WEST SUSSEX COUNTY COUNCIL CONSULTATION

TO:	Arun District Council FAO: Mrs A Gardner
FROM:	WSCC - Highways Authority
DATE:	3 September 2021
LOCATION:	30 Ellis Close, Arundel, BN18 9LG
SUBJECT:	AB/113/21/DOC Approval of details reserved by condition imposed under AB/39/18/PL relating to conditions 3-Construction Management Plan, 4-surface water drainage & 5-foul & surface water sewerage disposal.
DATE OF SITE VISIT:	n/a
RECOMMENDATION:	More Information
S106 CONTRIBUTION TOTAL:	n/a

This application seeks to deal with plans and details submitted in relation to conditions 3 (construction management plan), 4 (surface water drainage) and 5 (foul & surface water sewerage disposal) of the aforementioned planning approval.

Drawing Status	FOR APPROVAL		
Client	Arun District Council		
Project	S247 Stopping Up		
Drawing Title	Ellis Close, Arundel, BN18 9LG		
Scale	1:200	Date	08/07/21
Drawn By	MJA	Checked By	MJA
Drawing No.	D1955-203		Rev. B

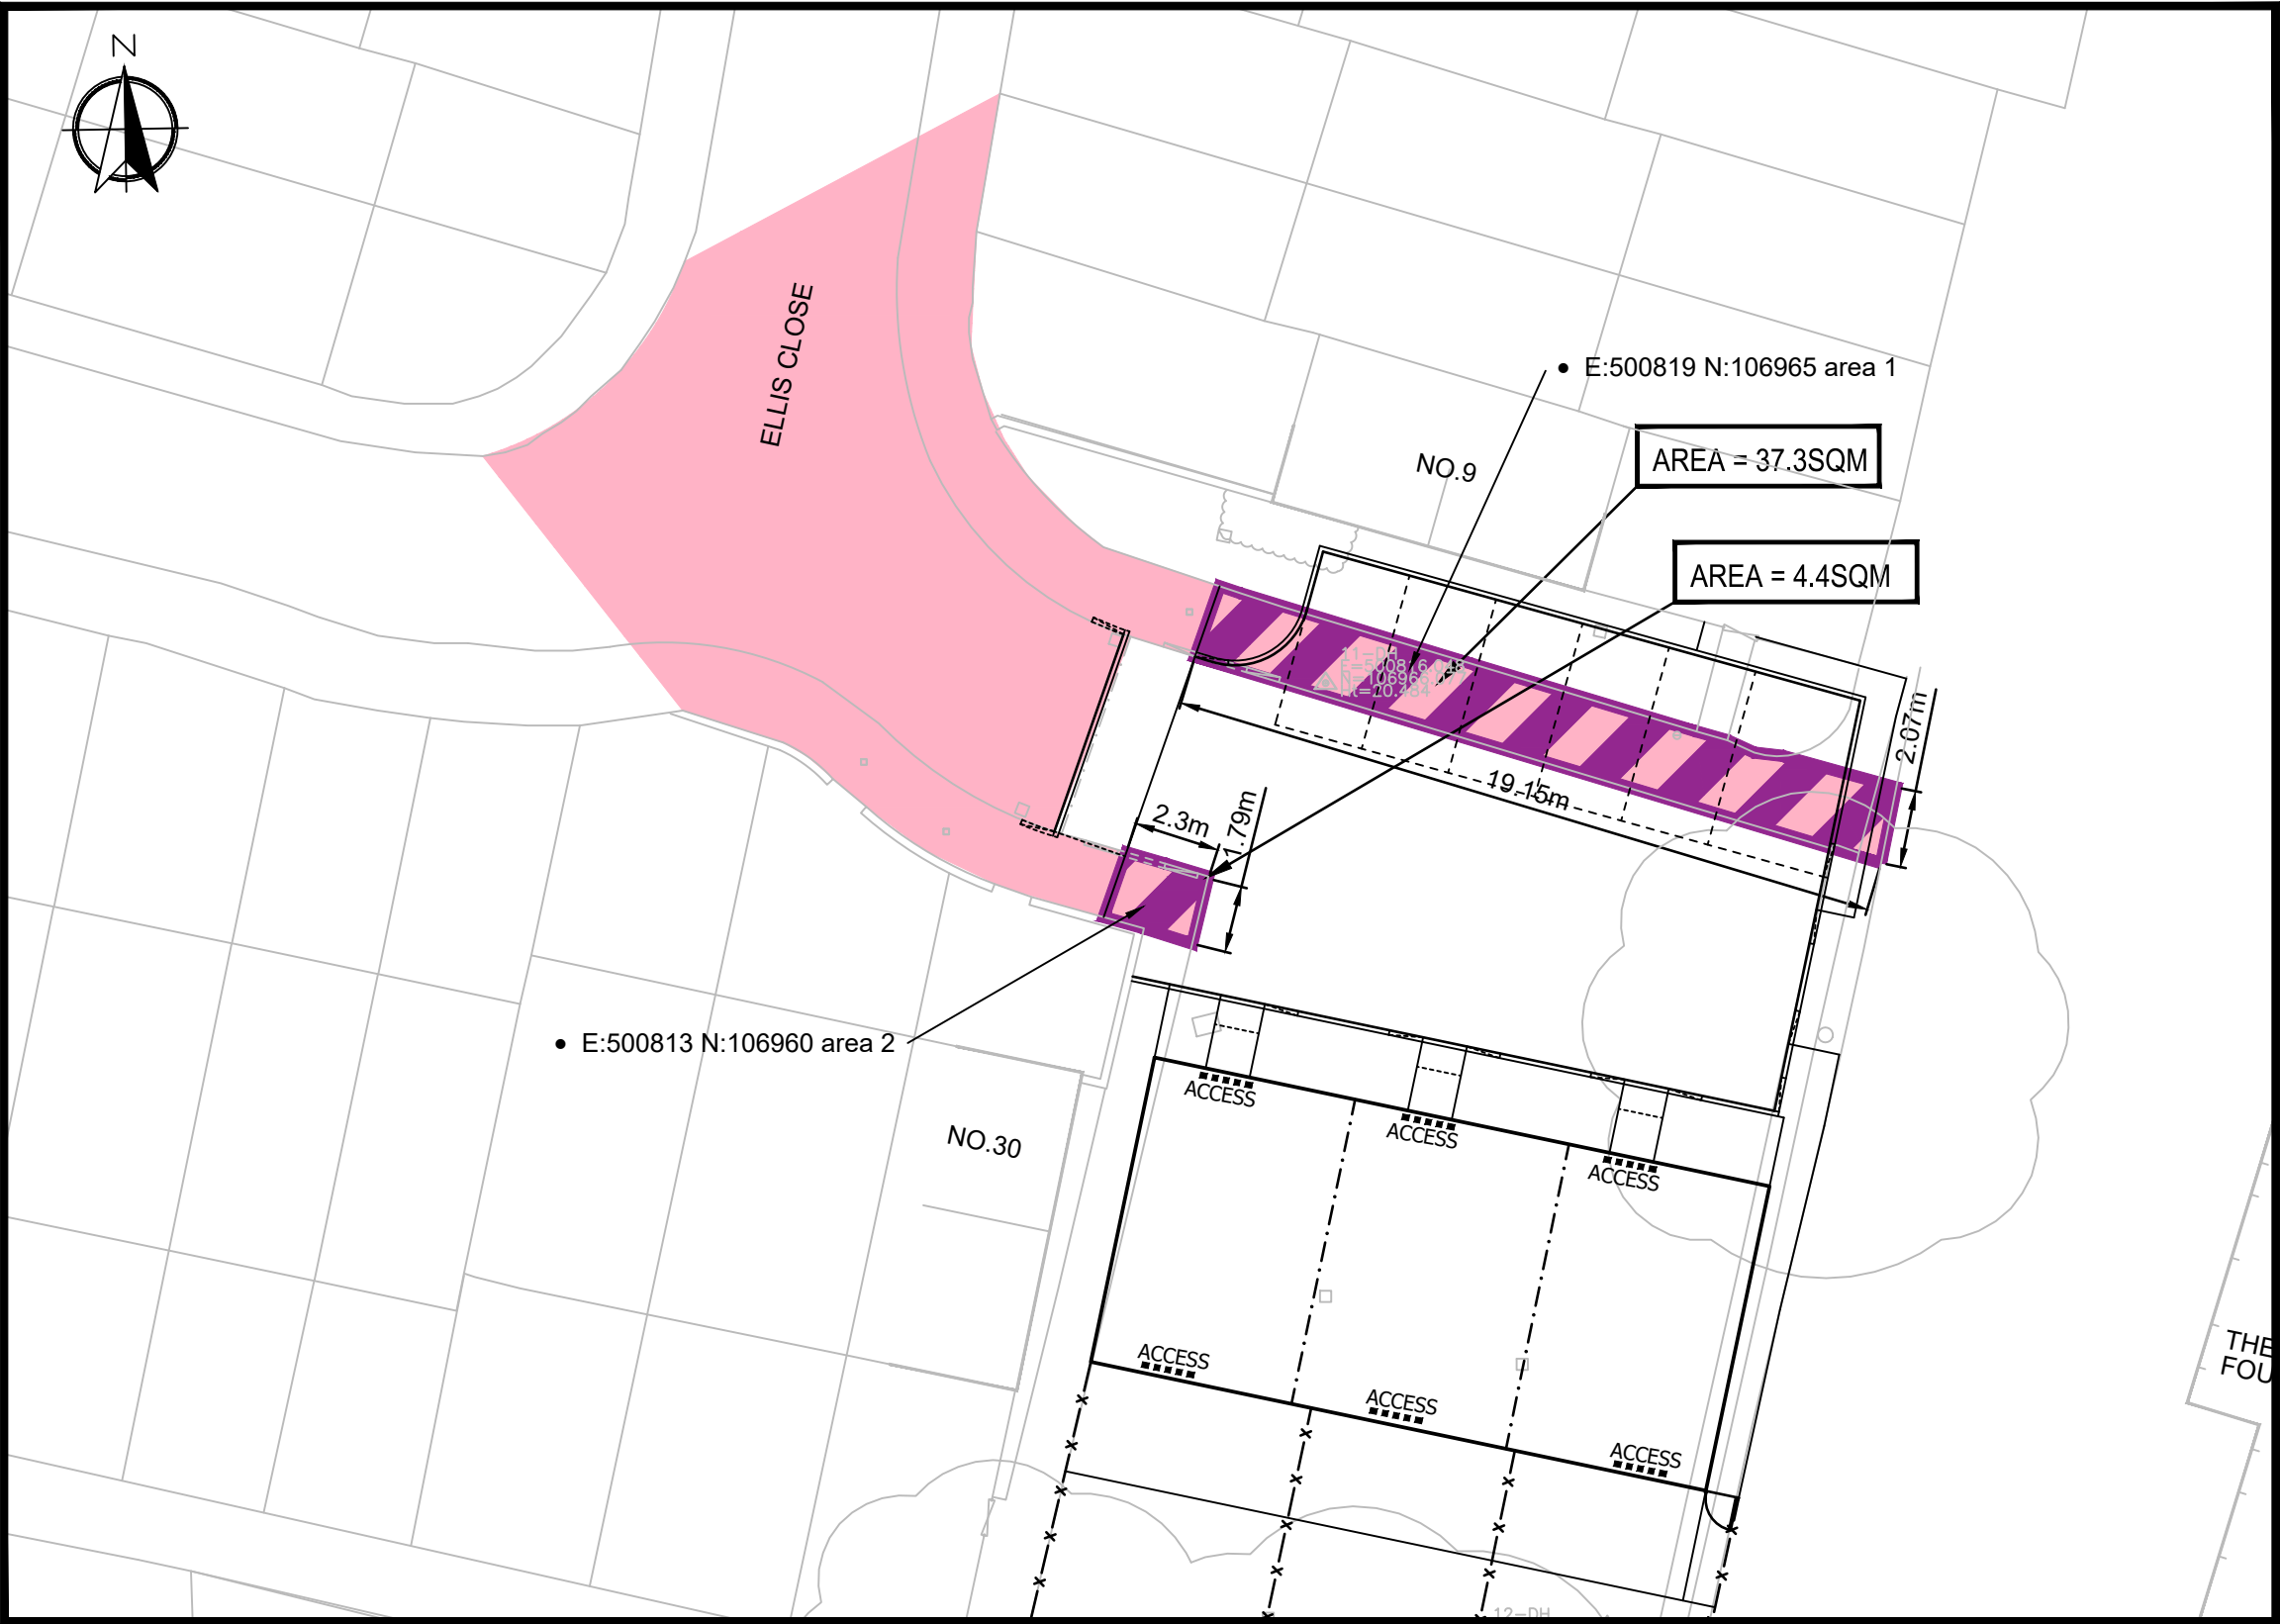
The principle of the development also includes the intention to 'Stop Up' two sections of existing public highway.

The location of any heras fencing / hoarding should be made clear as part of the Construction and Environmental Management Plan, particularly given the intention to 'Stop Up' some sections of public highway, so that a suitable informative can be provided if the fencing will obstruct the public highway.

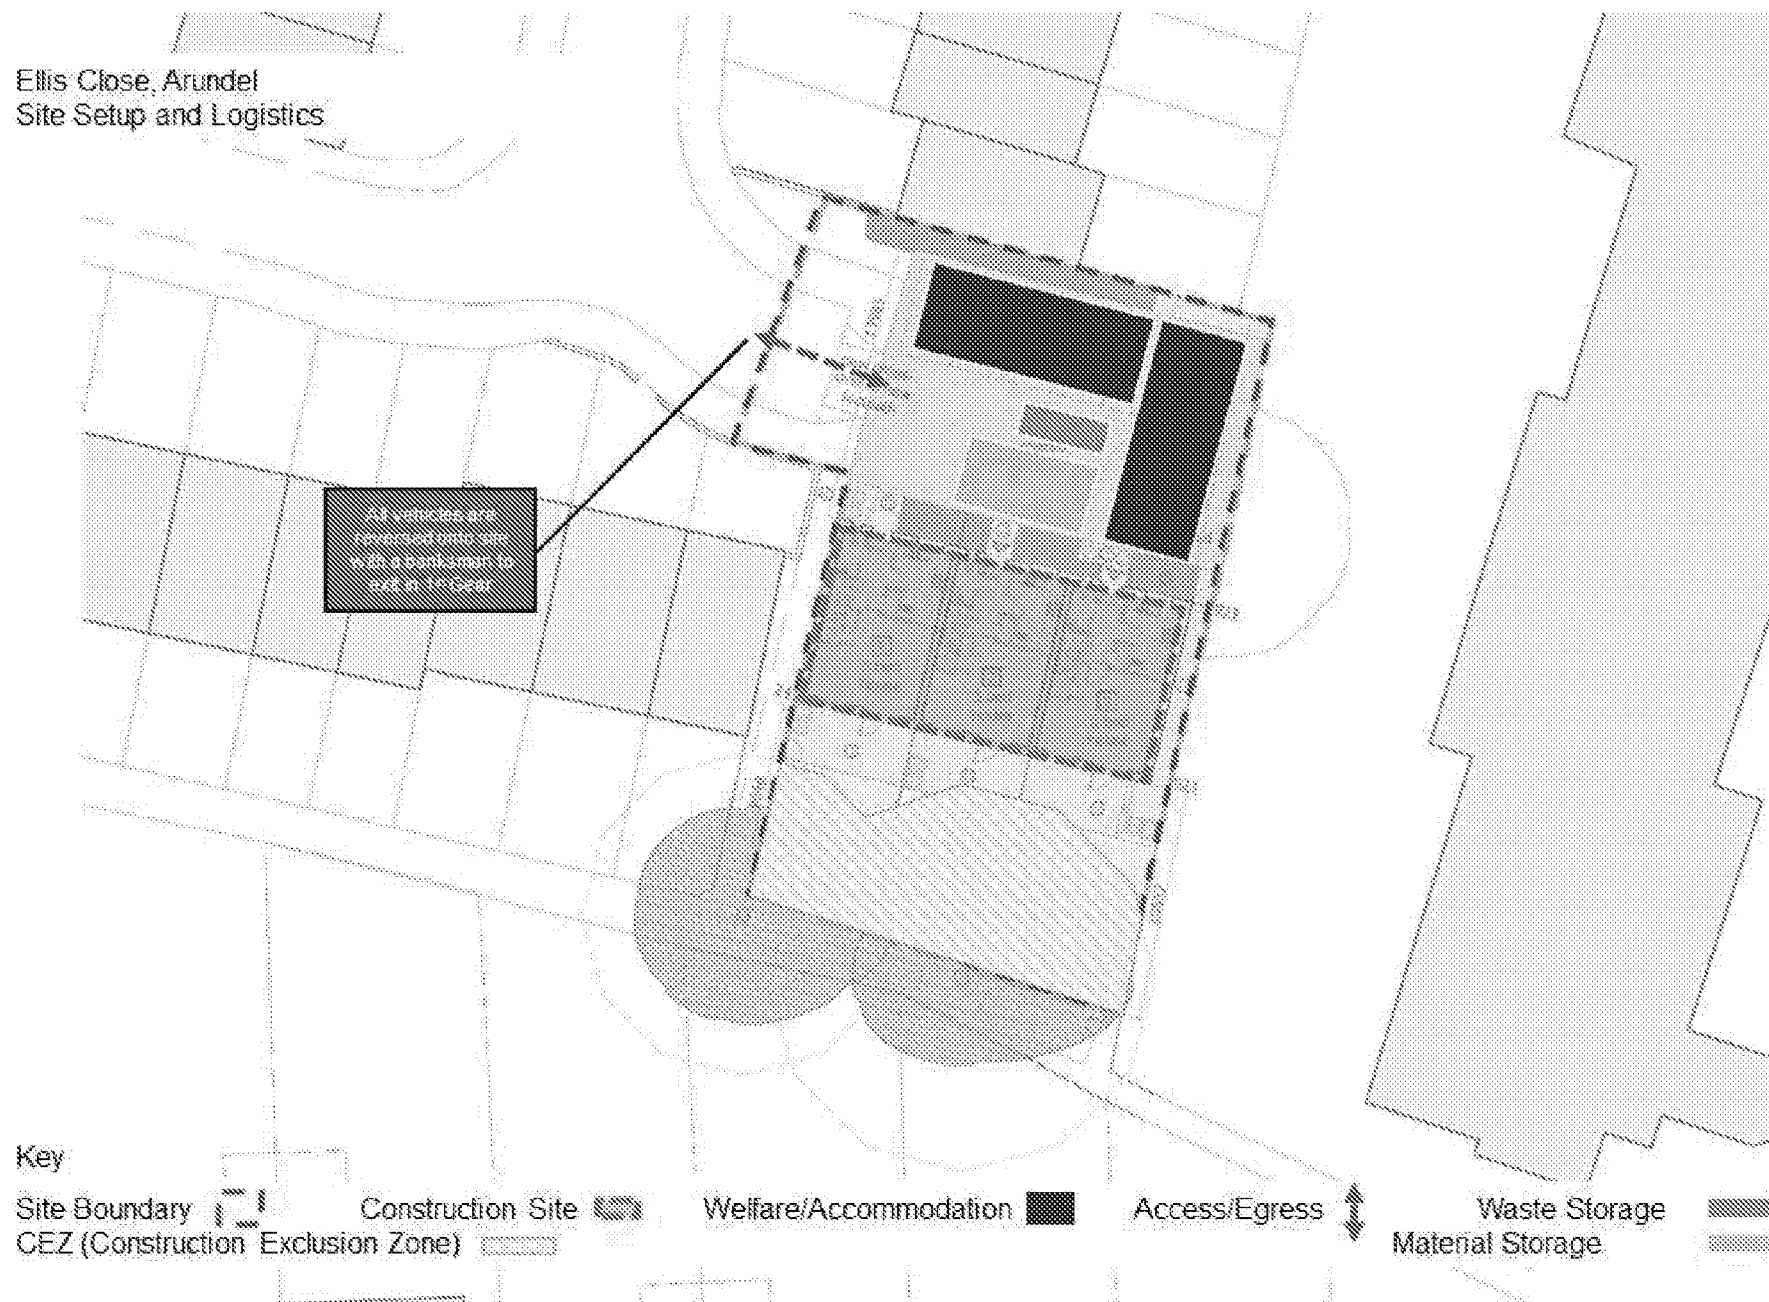
Notwithstanding the above the site set up plan within the Construction and Environmental Management Plan details the construction site 'outline'. It is not clear if all of these areas will be enclosed with heras fencing / hoarding.
